PLANNING APPLICATION REPORT**REF NO:** FG/79/09/**LOCATION:** 58 Elm Park
Ferring**PROPOSAL:** Loft extension, replacement conservatory and garage extension (re-submission following previously approved FG/23/09)**SITE AND SURROUNDINGS**

DESCRIPTION OF APPLICATION	The proposed amendments increase the eaves of the property to approximately 3m high and the ridge height to approximately 7.3m high.
SITE AREA	Approximately 511 square metres.
RESIDENTIAL DEVELOPMENT DEN	N/A
TOPOGRAPHY	Predominantly flat
TREES	None of any significance affected by the proposed development.
BOUNDARY TREATMENT	Dwarf brick wall to the front of the property approximately 600mm high.
SITE CHARACTERISTICS	Detached single storey property. Red brick walls, hipped red tile roof with gable section. Flat roof garage to the side of the property. Open porch to the front of the property.
CHARACTER OF LOCALITY	The site is located within a cul-de-sac. Characterised by residential bungalows, many of which have been extended. Neighbouring property to the south has extensions to the rear and dormer window within the front elevation.

first floor

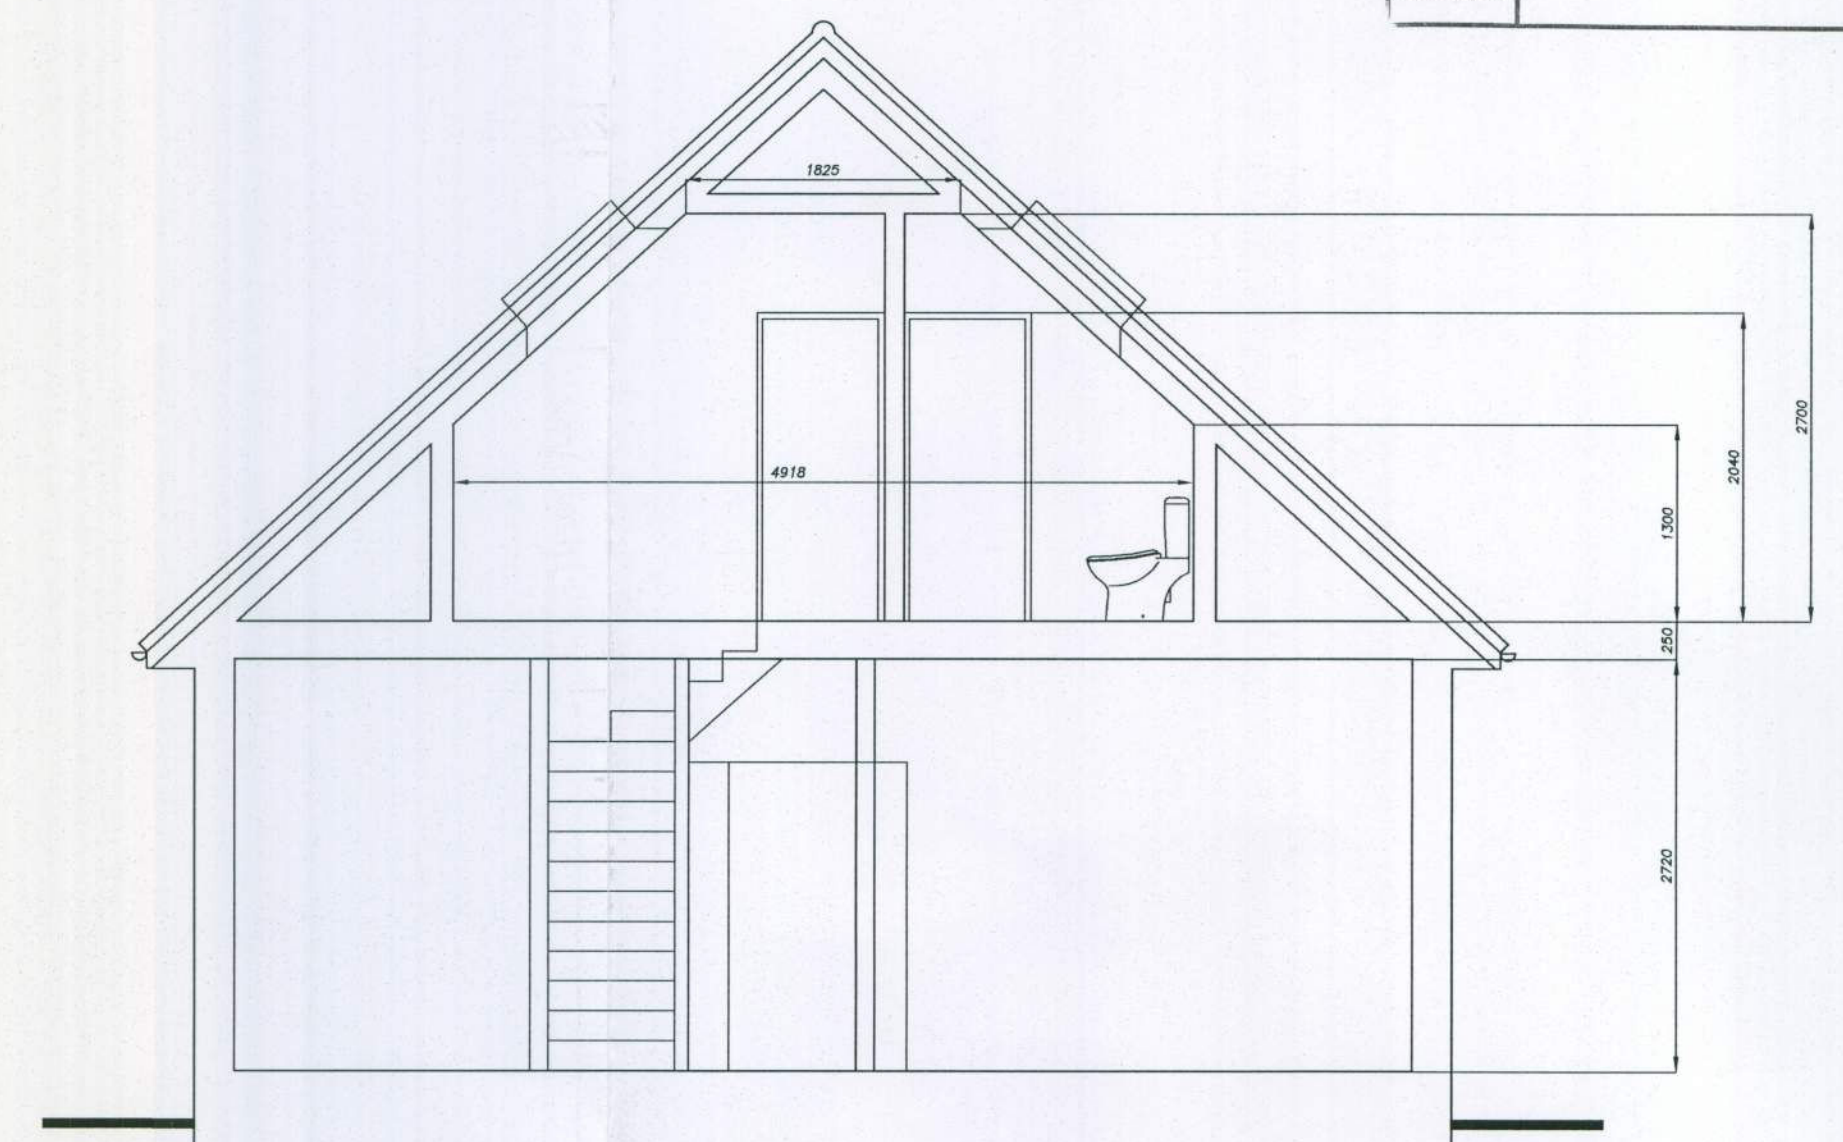
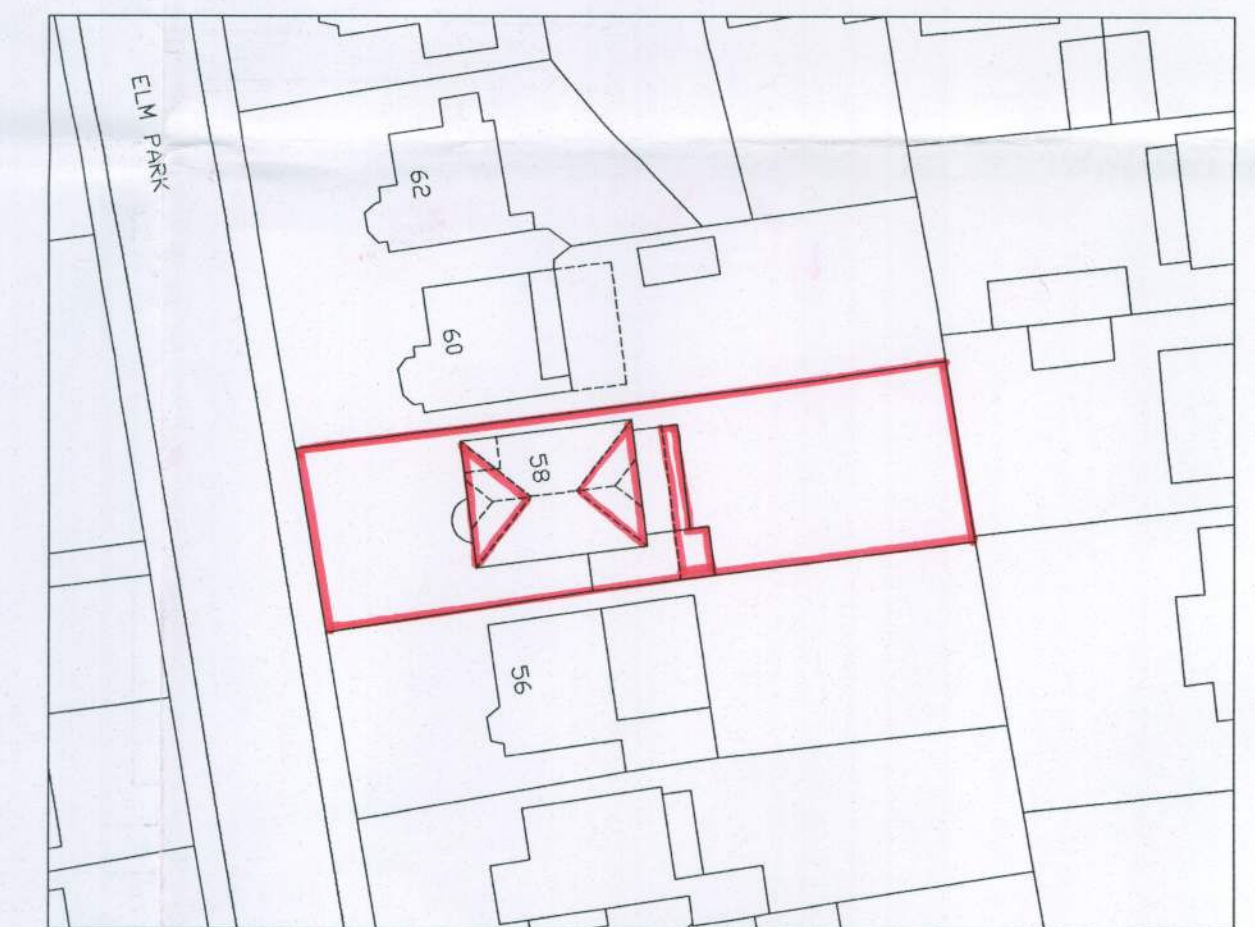
The proposed 1st floor fenestrations will face the front and rear of the property with only oblique

views available of the rear gardens of the neighbouring properties. The views from ground floor windows will be screened by the existing boundary treatment, therefore the development is not considered to result in demonstrable loss of amenity to the neighbouring properties by way of overlooking.

Proposed Elevations
Scheme 3

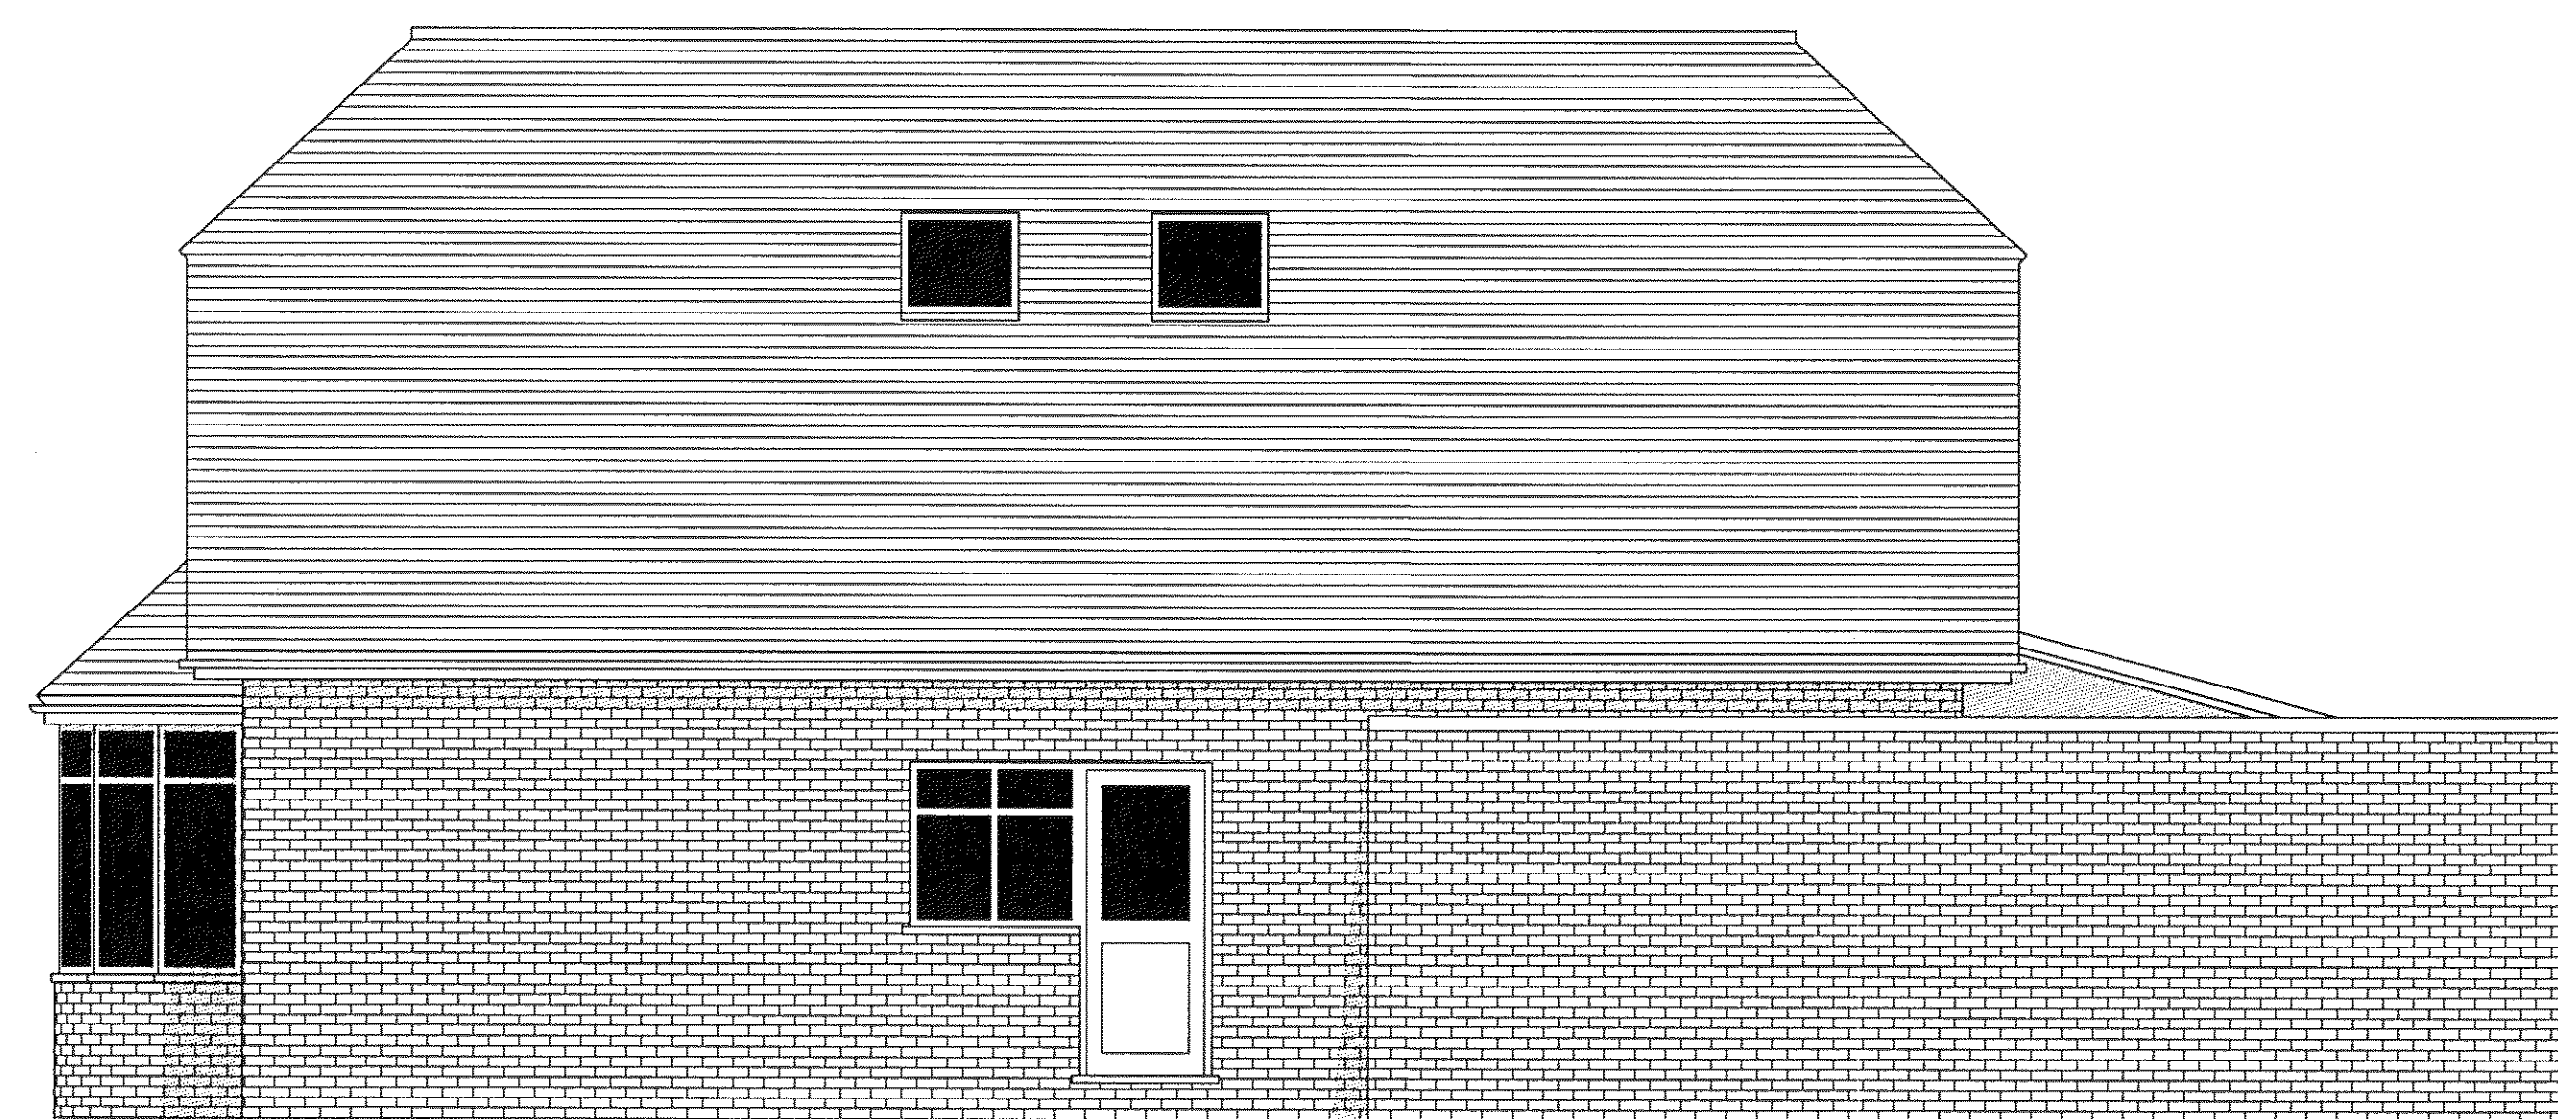
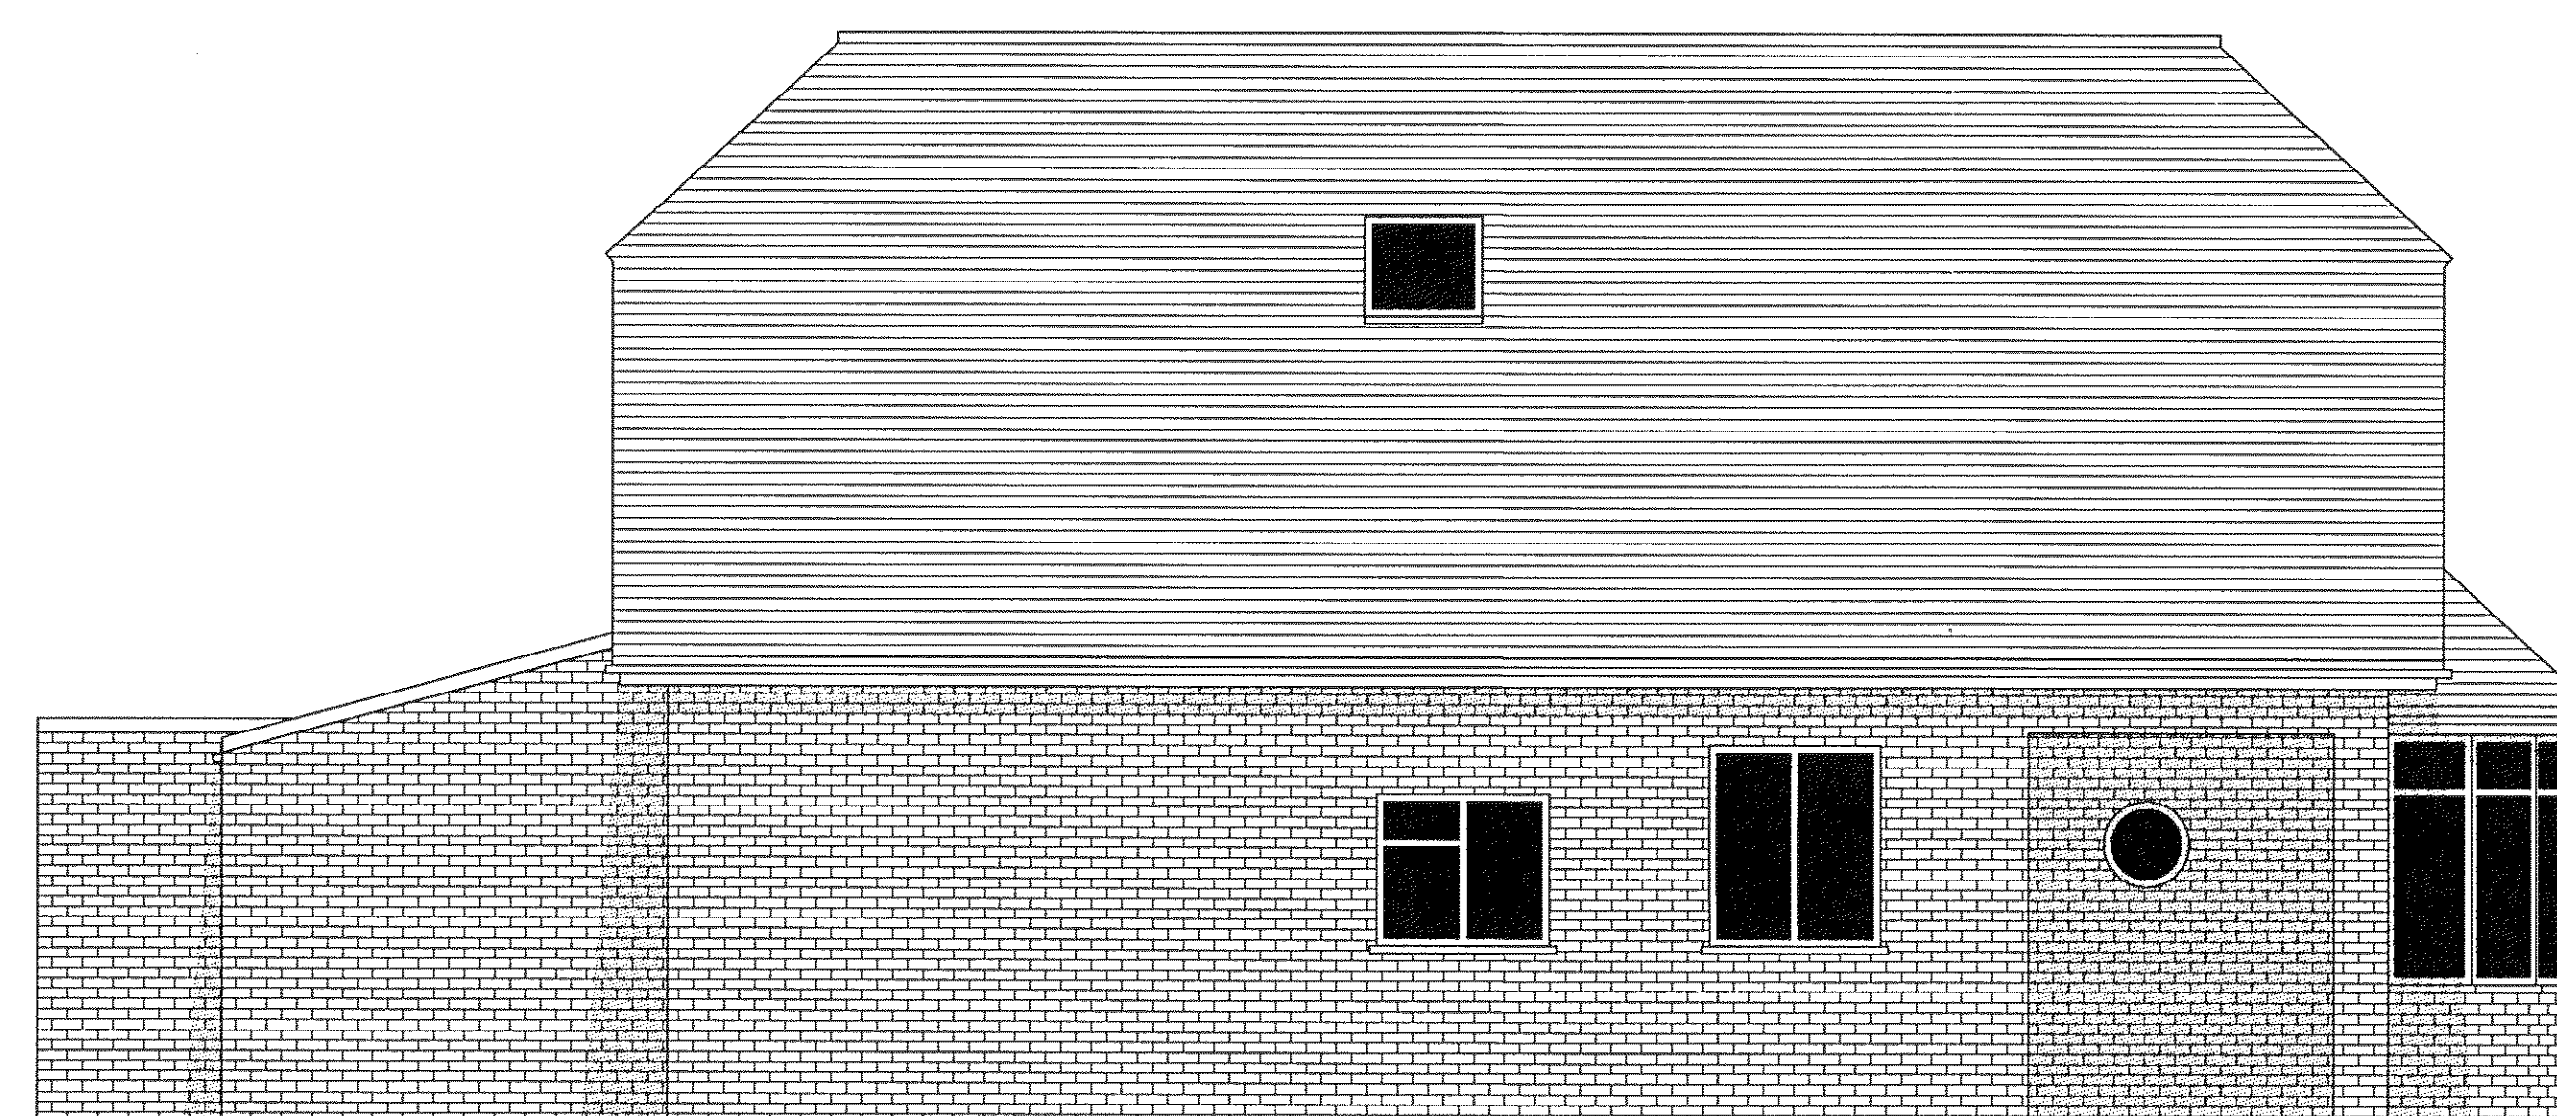
The proposed application seeks permission for amendments to the previously approved application FG/23/09. The overall increase of the height of the proposal to that existing will be approximately 300mm.

The increased height of the property by approximately 300mm will be visible within the street scene, however it is not considered to detract from the character and appearance of the street scene. The proposal is therefore not considered to give rise to unacceptable loss of amenity to the neighbouring property by way of overbearing affect or loss of light. The amendments appear to be acceptable in that the development will continue to relate to the character of the existing dwelling and will not be out of keeping with the neighbouring properties particularly given that they are of similar design.
